# TR050007 Hinckley National Rail Freight Interchange

## Stoney Stanton Action Group

Comments on additional information supplied by TSH (10<sup>th</sup> Dec 2024) in response to the SoS's letter (10<sup>th</sup> Sep 2024)

5/2/2025

Proposed Layout - 16.5m Max Legal Articulated Vehicle

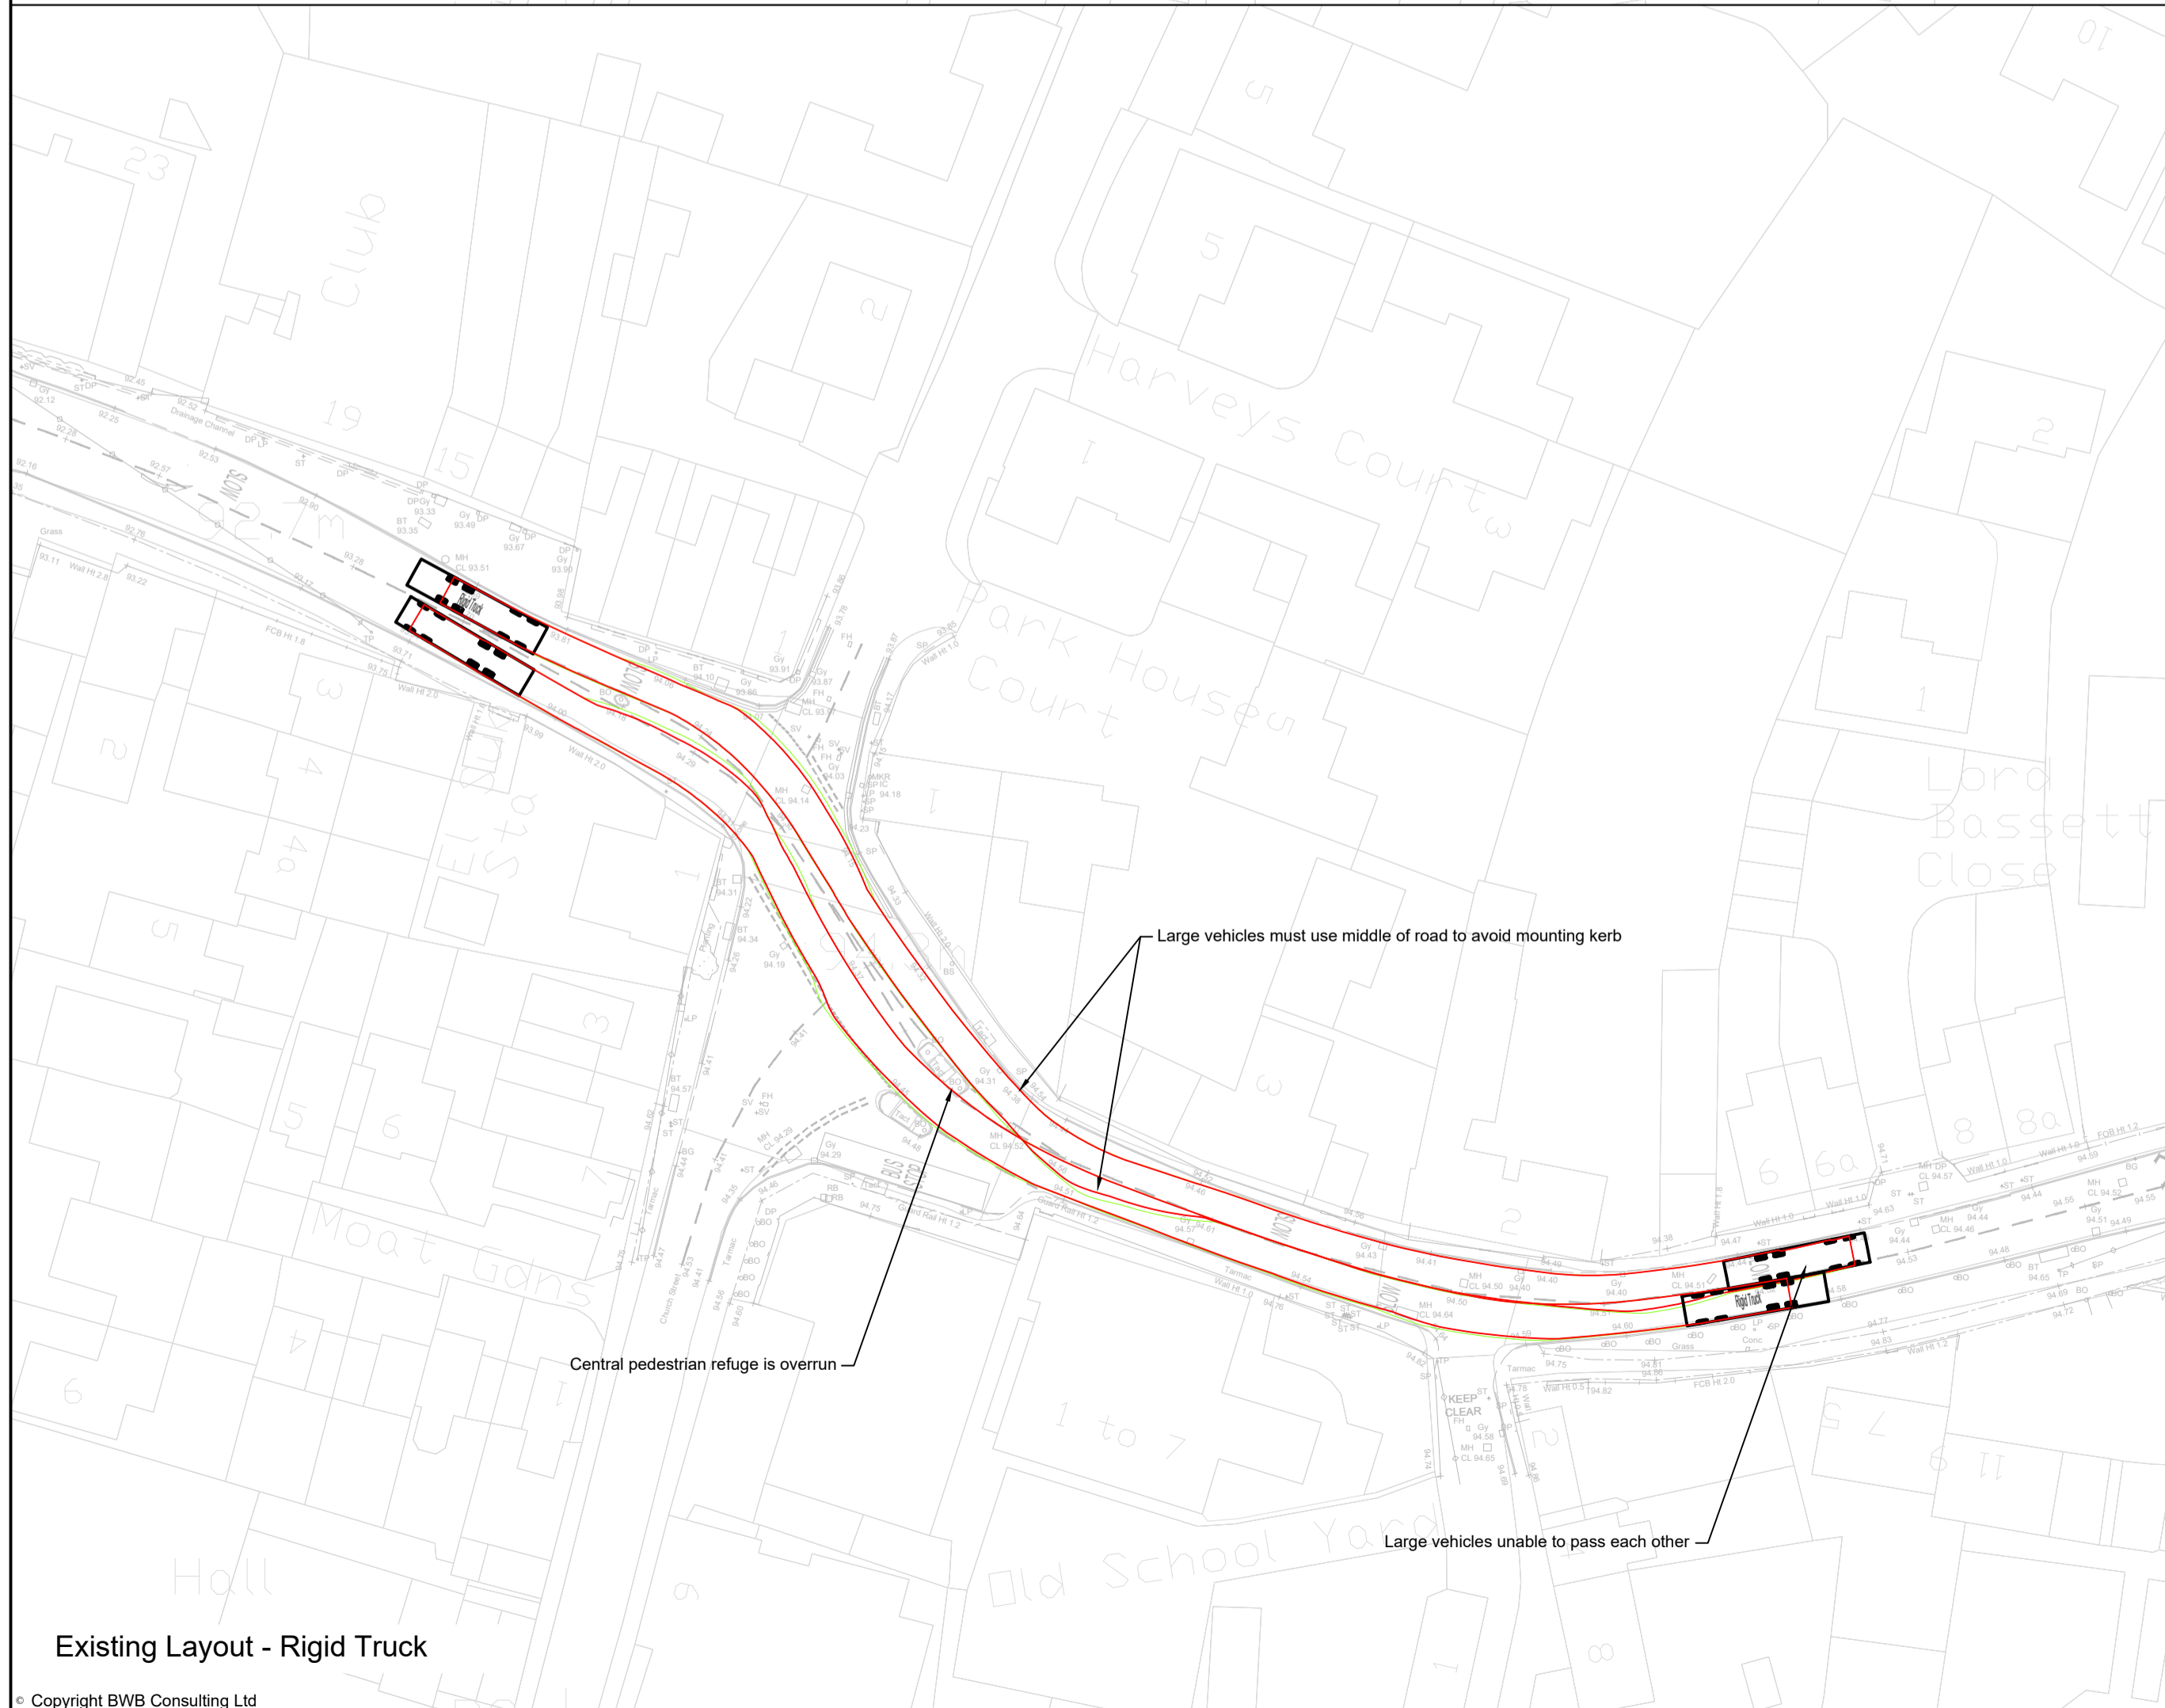
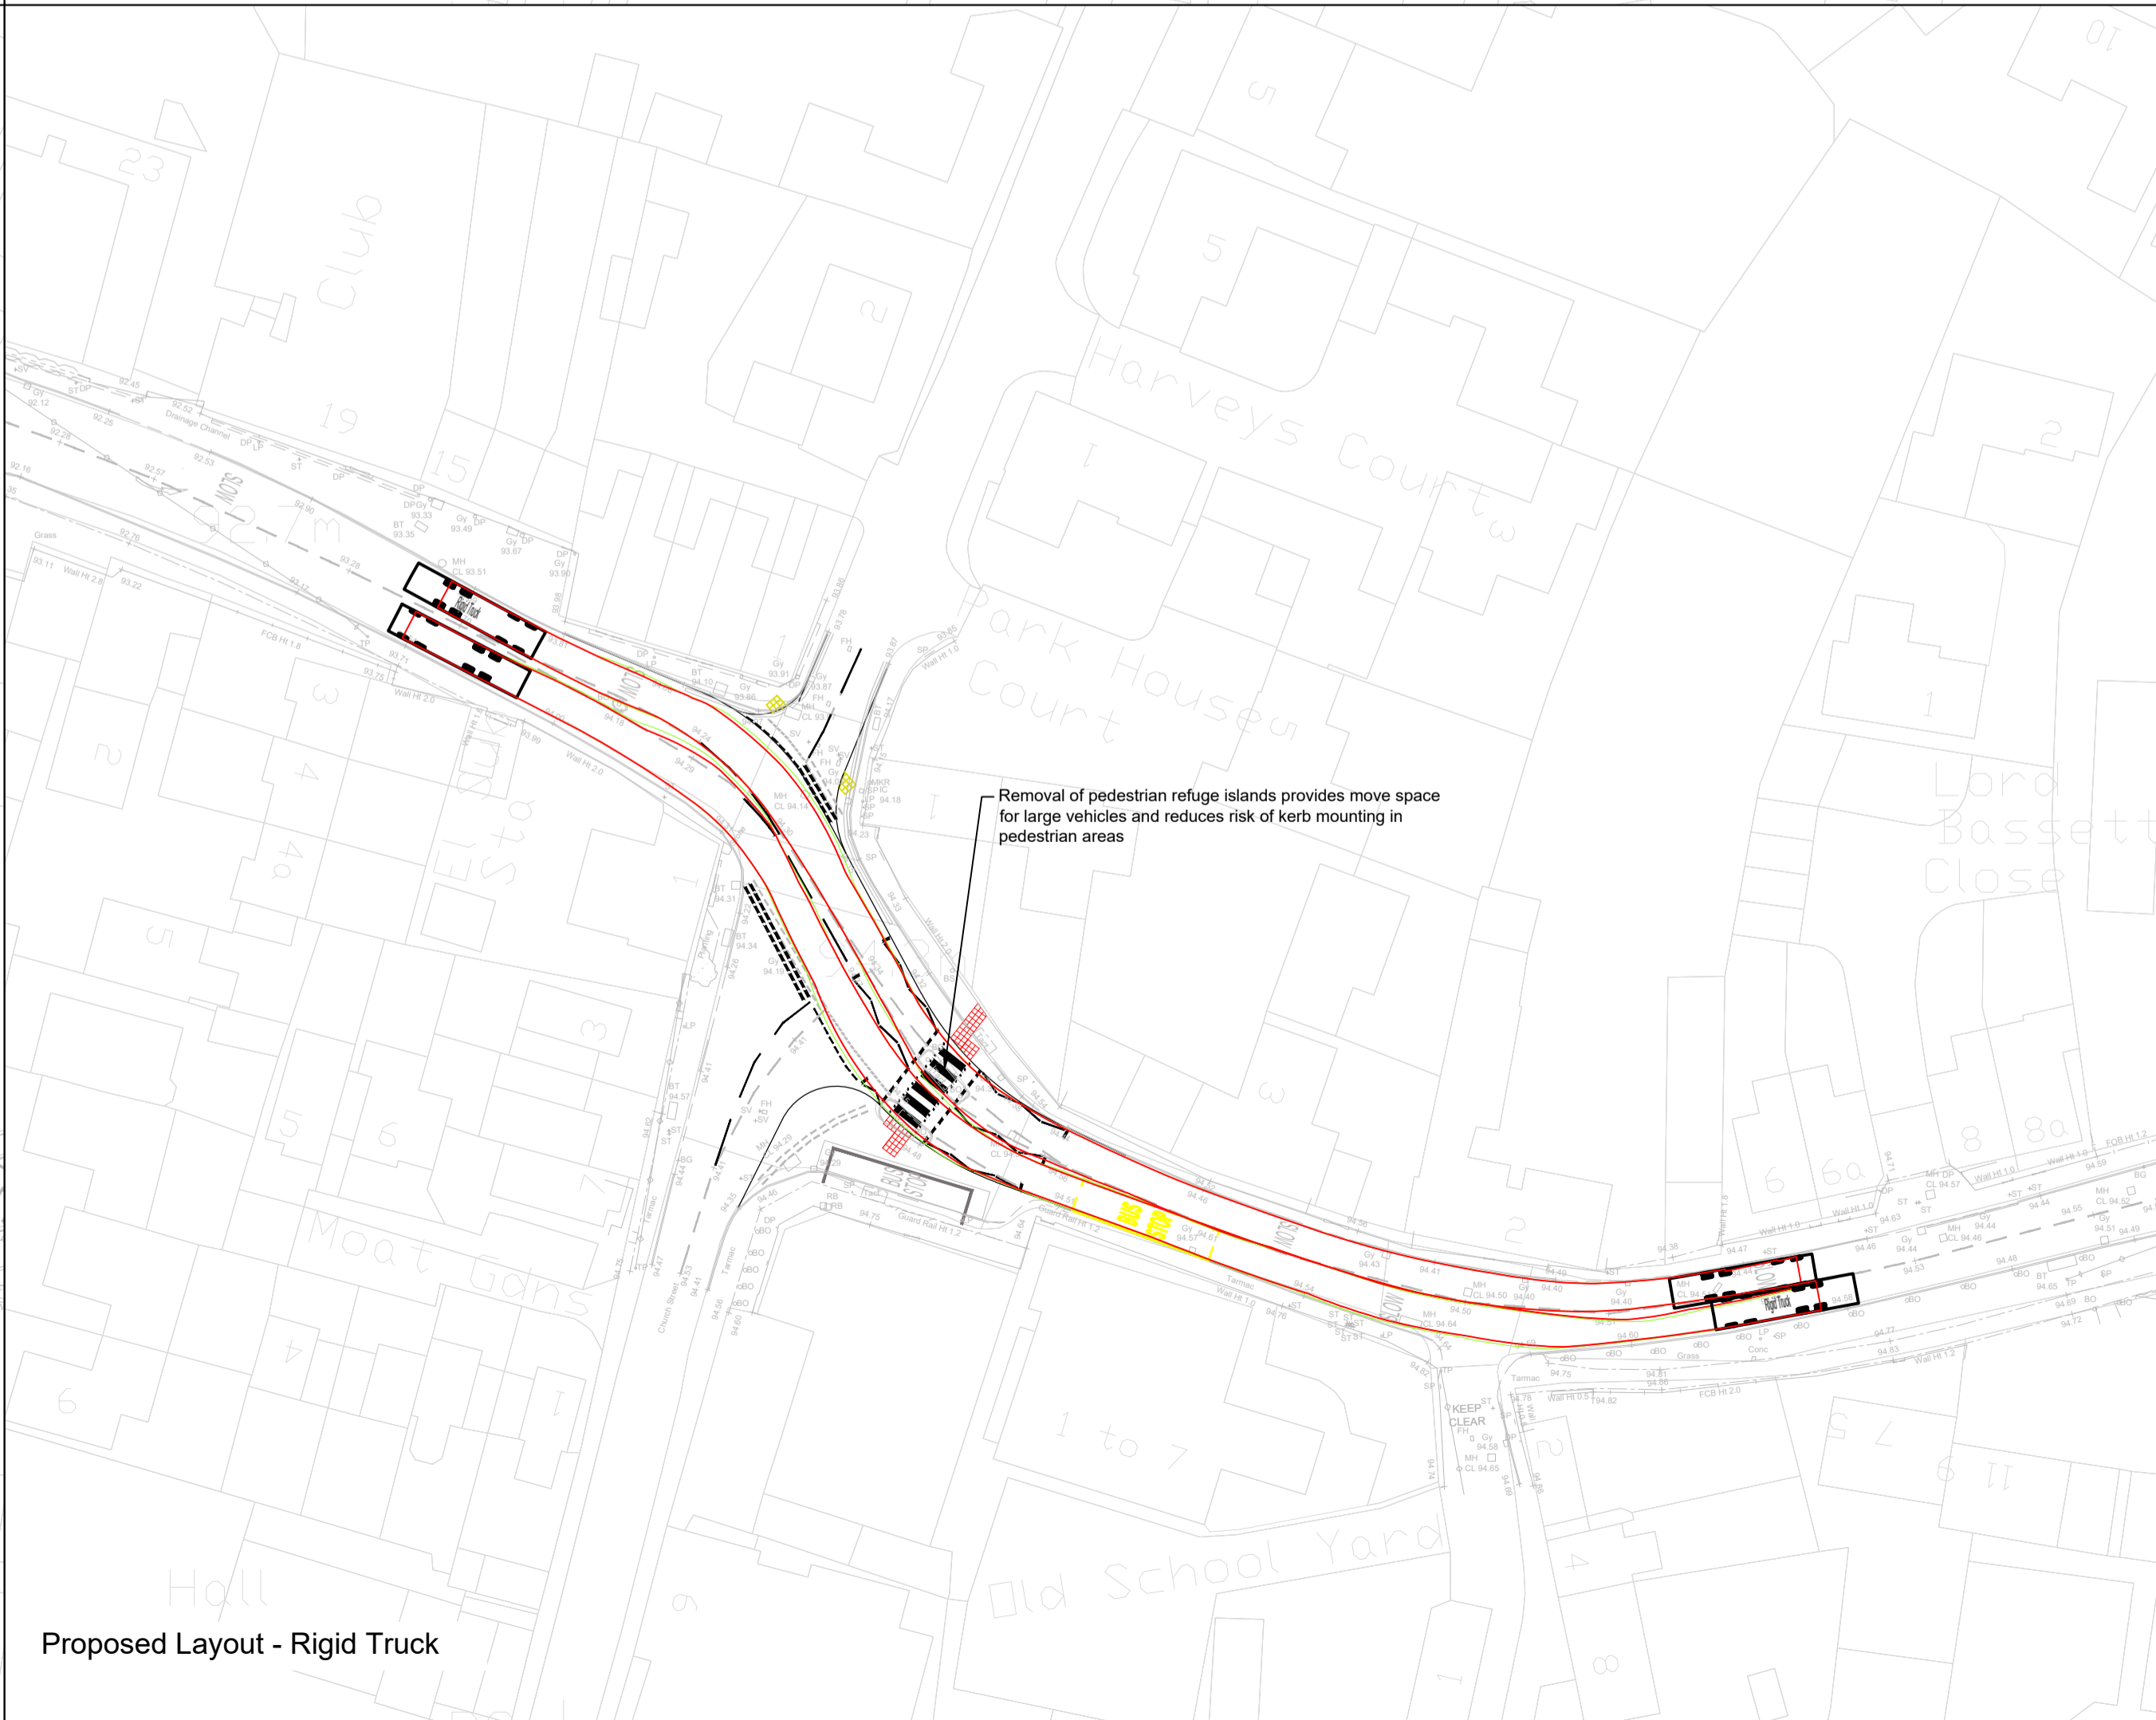
From a cursory read through "Appendix 2 - Sapcote Technical Note", another document that is overly dismissive of valid concerns. Table 2.1 in Section 2.12 of that document shows vehicle numbers for the B4669 to the West of the Co-op (Link 41) and to the East of the Co-op (Link 43). The HGV Annual Average Daily Traffic figures are inconsistent, for instance 2026 (scenario ii) Westbound is shown as 170 for Link 41 and 93 for Link 43. The difference is explained in section 2.13 by stating this shows that there is a significant proportion of local HGV traffic. From local knowledge it is easy to deduce that this is not likely, as all possible other destinations (e.g. Church Street and Stanton Road) are difficult to access by HGV. Additionally Westbound traffic for the Western Link (Link 41) increases by 10 in 2026 "with development", whereas the Westbound Traffic for Eastern Link (Link 43) increases by 1 in 2026 "with development". Either the HNRFI is creating additional local HGV traffic or the table is wrong. See photos in this document Section 4.
